From: Laura Gibbons
Sent: 05 November 2018 13:31
To: 'Vlad Myrsikov'
Cc: Sarah Hufford; Anita Gardner; Paul Cann
Subject: RE: EP/98/18/DOC - Tudor Cottage, 125A Sea Road

L2340-C-52-750 – Drainage for Planning

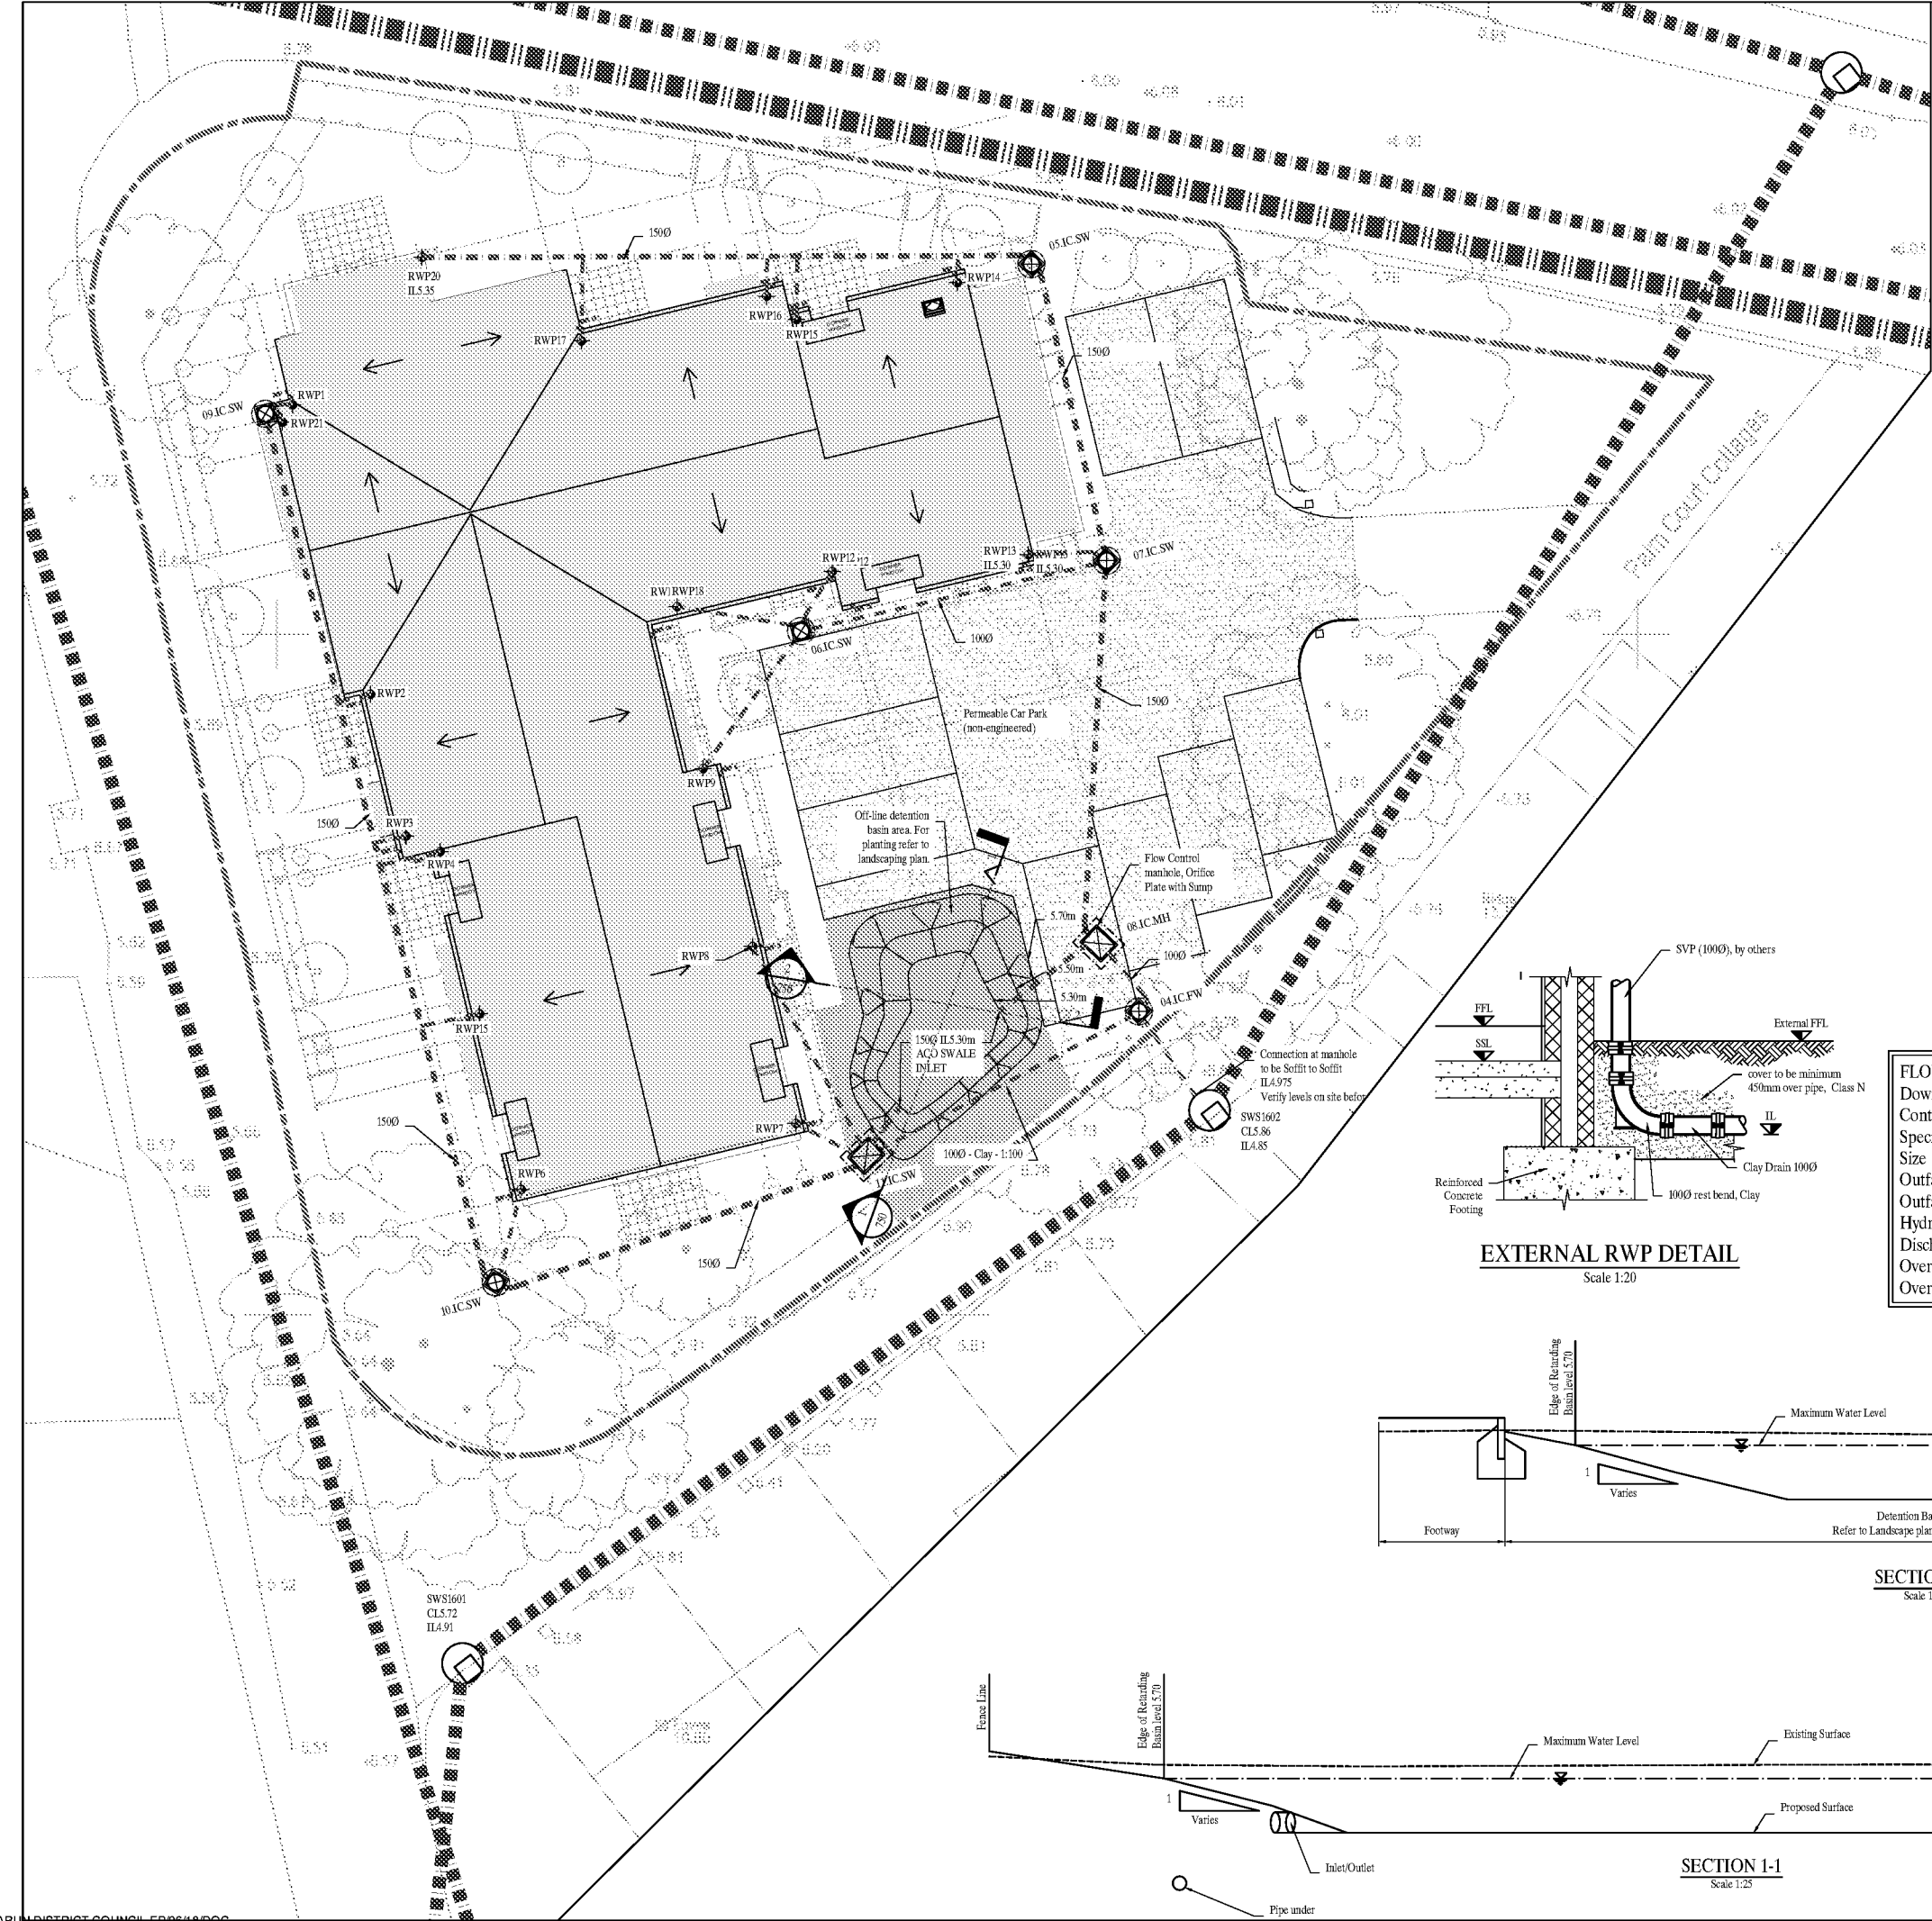
1. Please detail on the layout plan the pond invert levels and bank levels.
2. Please ensure all water goes through the pond before reaching the flow control device. I would advise two inlets to the pond and one outlet which has the flow control device. At the minute the water is being able to bypass the pond at flows which are less than the restricted rates, therefore whenever it was raining water would be going into the sewer. We would like to see the sewer connection used as more of an overflow.
3. Please provide calculations of this revised arrangement.
4. Please detail proposed levels of the car park area. As you have provided no quantifiable proof that your proposal for the car park would work can levels be set so that there is a gentle fall to the pond rather than surrounding land.
5. Please provide construction detail drawings of the non-engineered permeable pavement.

We do not require 1m clearance between the base of infiltration structures and maximum recorded winter groundwater levels. The base of infiltration structures must be sited above maximum recorded groundwater level. There is space for permeable paving, and for the pond to be infiltrating rather than attenuating.
